Mr William Simcock
Planning Department
Kirklees Council
Via email

21 April 2026

RE: 2025/65/92140/E (JCNAS 216894) | The Old Dewsbury Library, Wellington Road, Dewsbury, WF13 1HN (Grade II, G. E. T. Lawrence, 1896, alterations in 1931 and mid C20th). Application for conversion of library into 14 one- and two-bedroom apartments. Associated repairs, alterations and landscaping, erection of external bike storage.

GROUND FLOOR PLAN
1:100

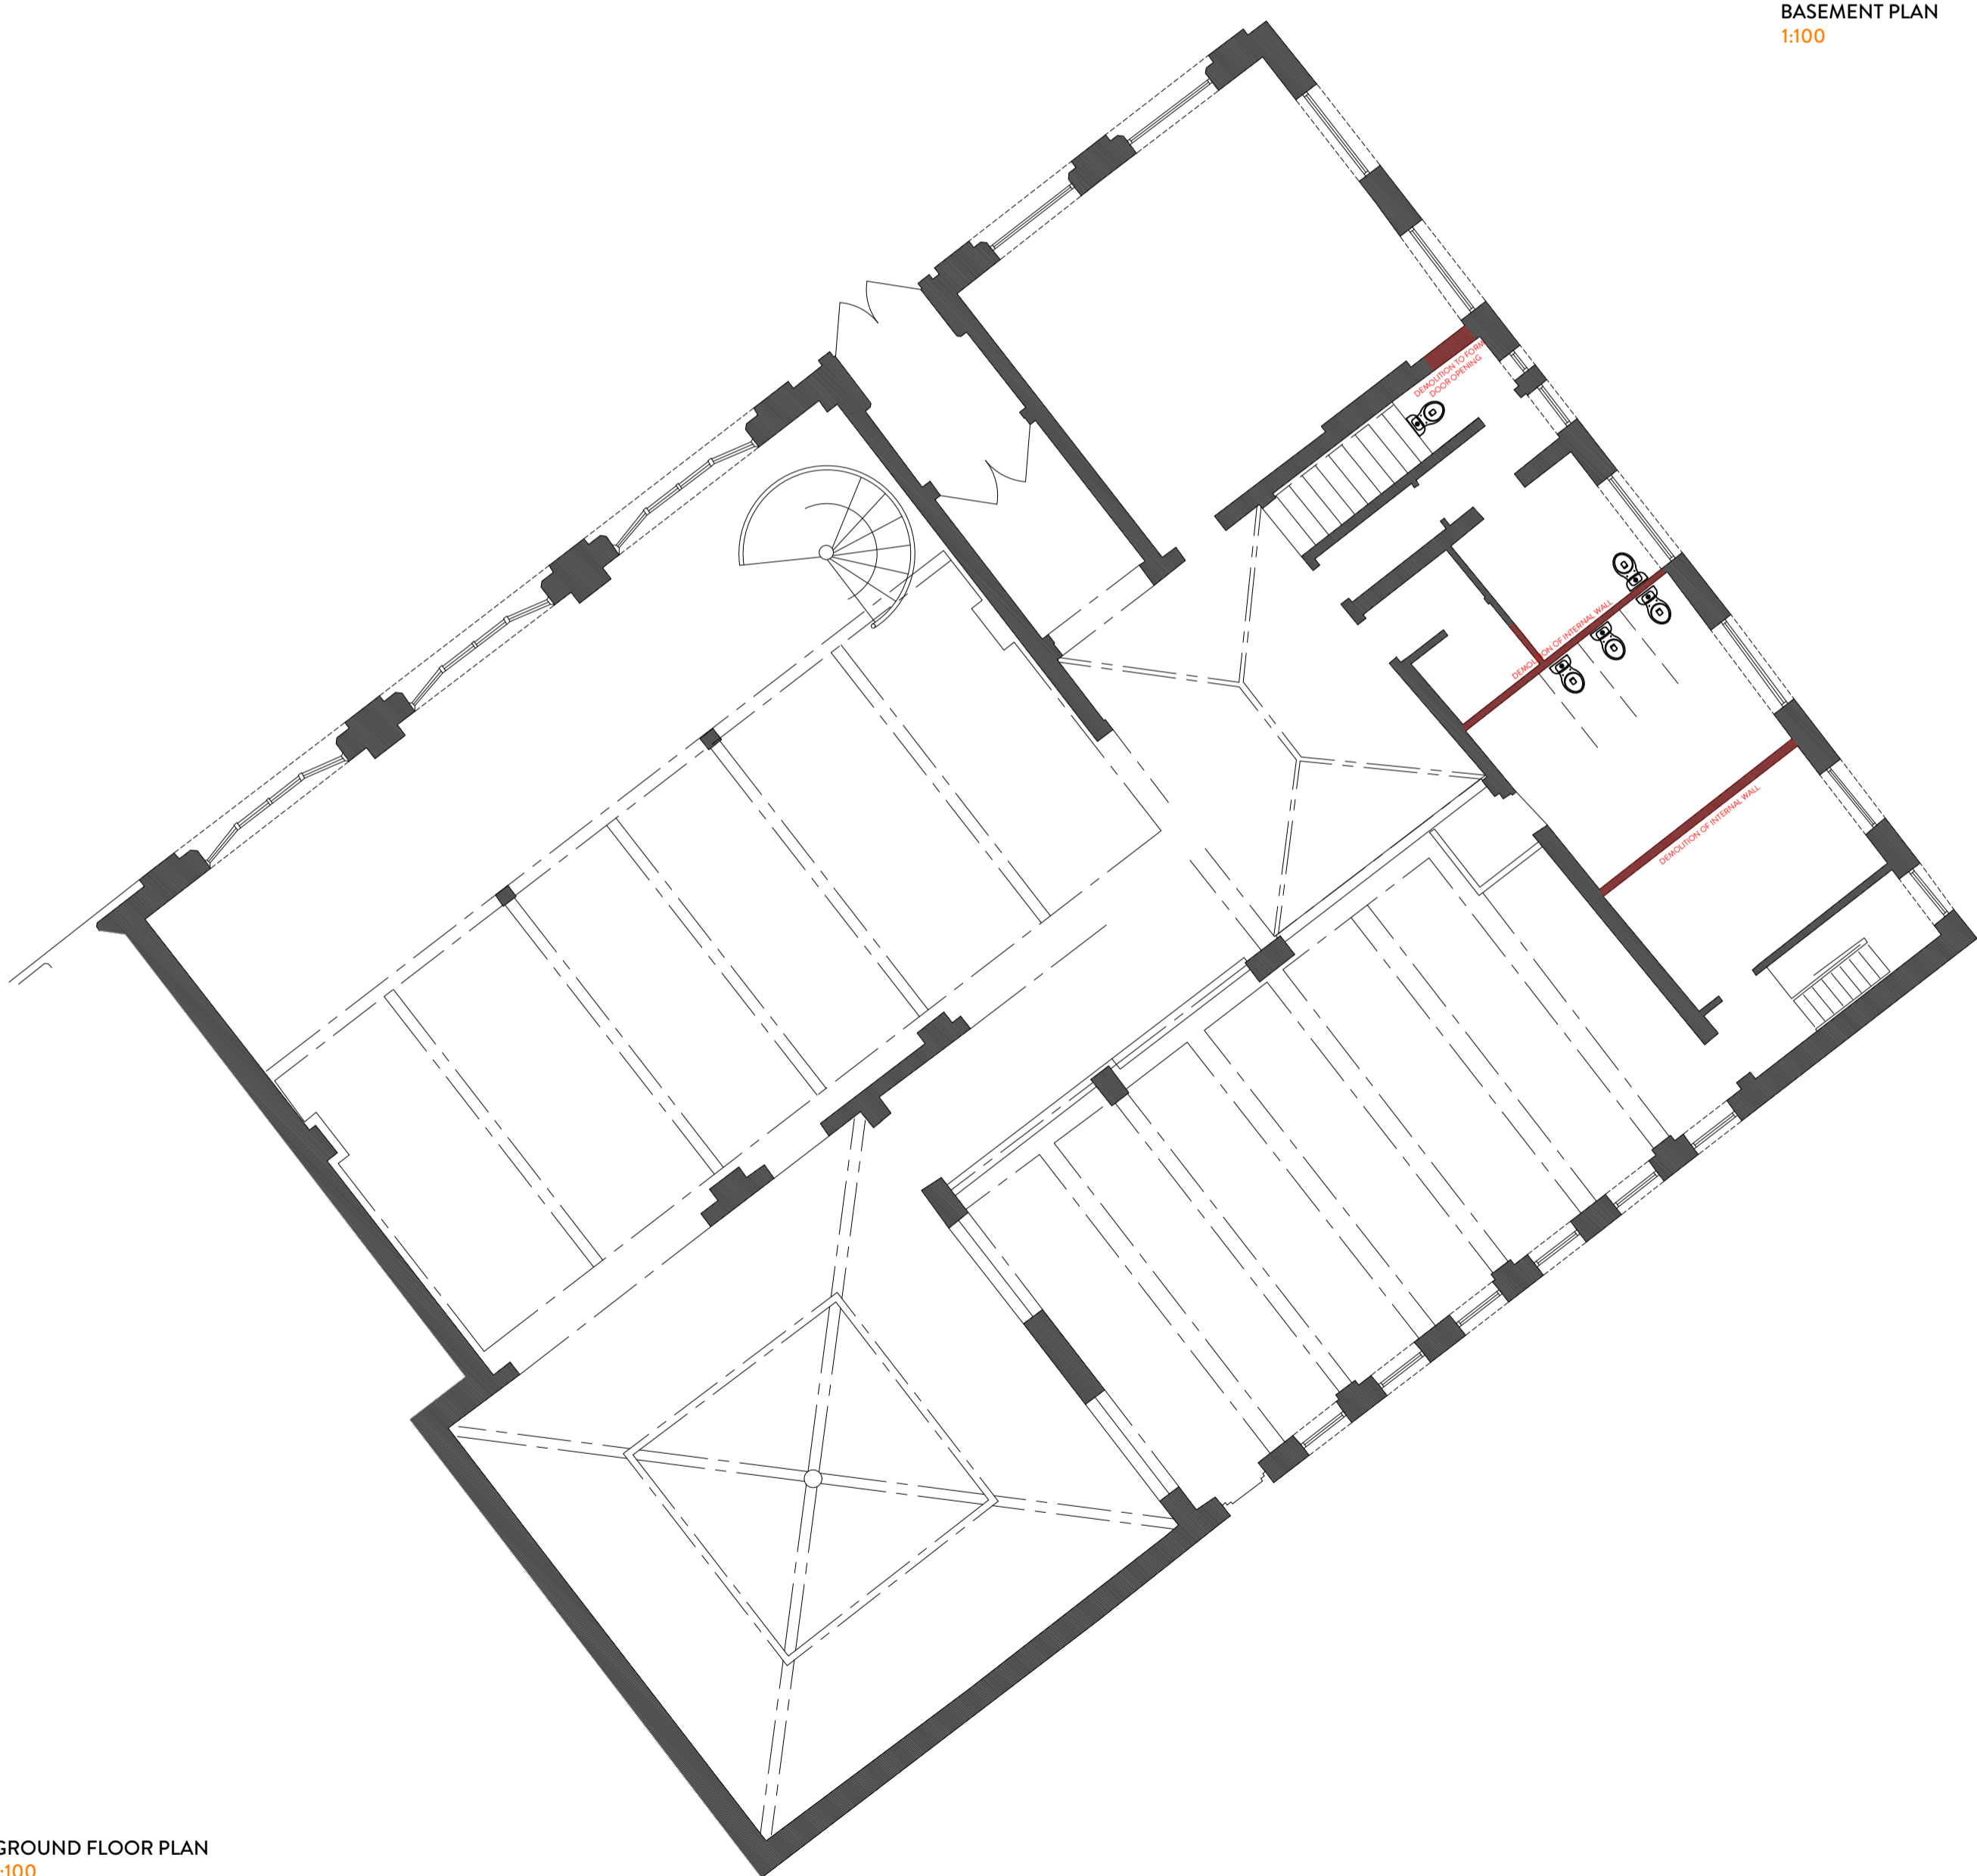
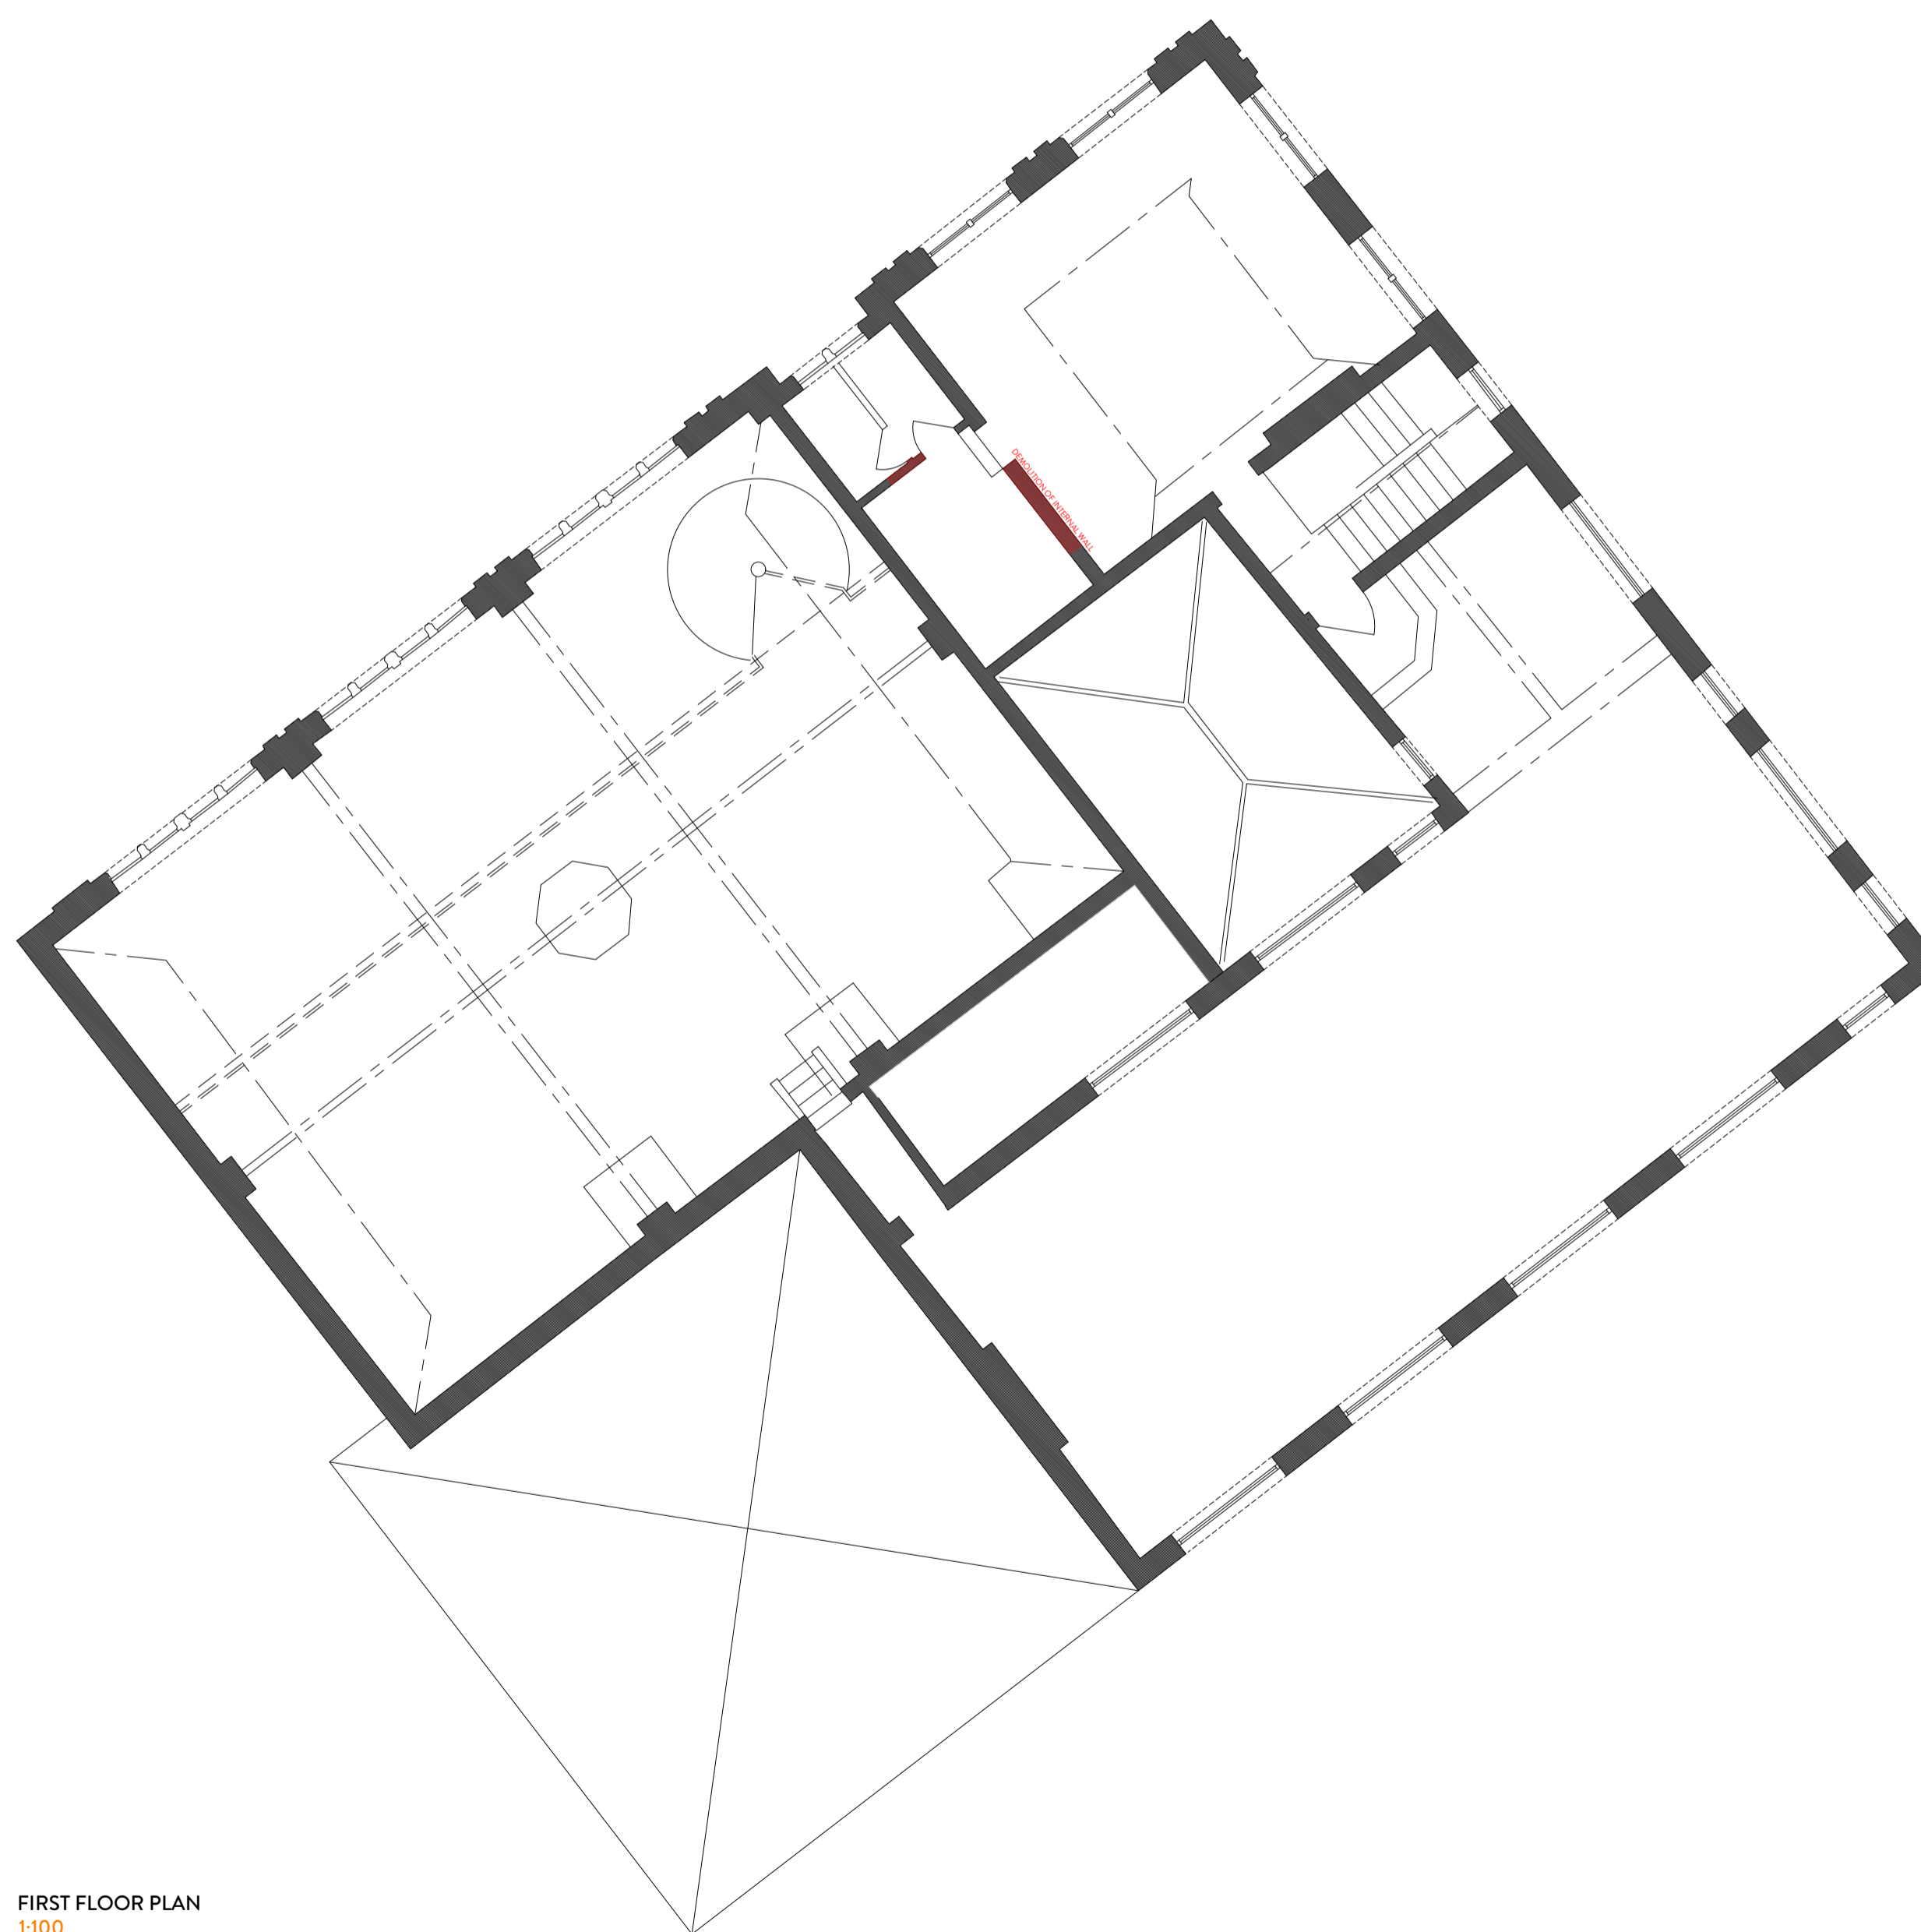
As a Society, we recommend that more information is provided regarding how the cupola and lantern is to be replaced, how the decorative ceiling is to be boxed-in, and how the 1931 mural is to be '*maintained in a communal area for all to view*'. As it stands, there is a severe lack of detail in these proposals, and we are concerned that unjustified harm may take place in this conversion. More detail as to the nature of the changes, and more detailed plans, should be supplied before this application can be considered by your Authority.

During the meeting of our Buildings Committee, it was discussed that 14 flats in such a small building could border on overdevelopment. A smaller number of flats would be less intrusive and allow for the historic planform to be retained to a greater extent. This would likely also remove the need to box-out the decorative ceiling that is specifically highlighted in the list description. As it stands, covering this feature will not enhance the buildings national significance or allow its character to be read.
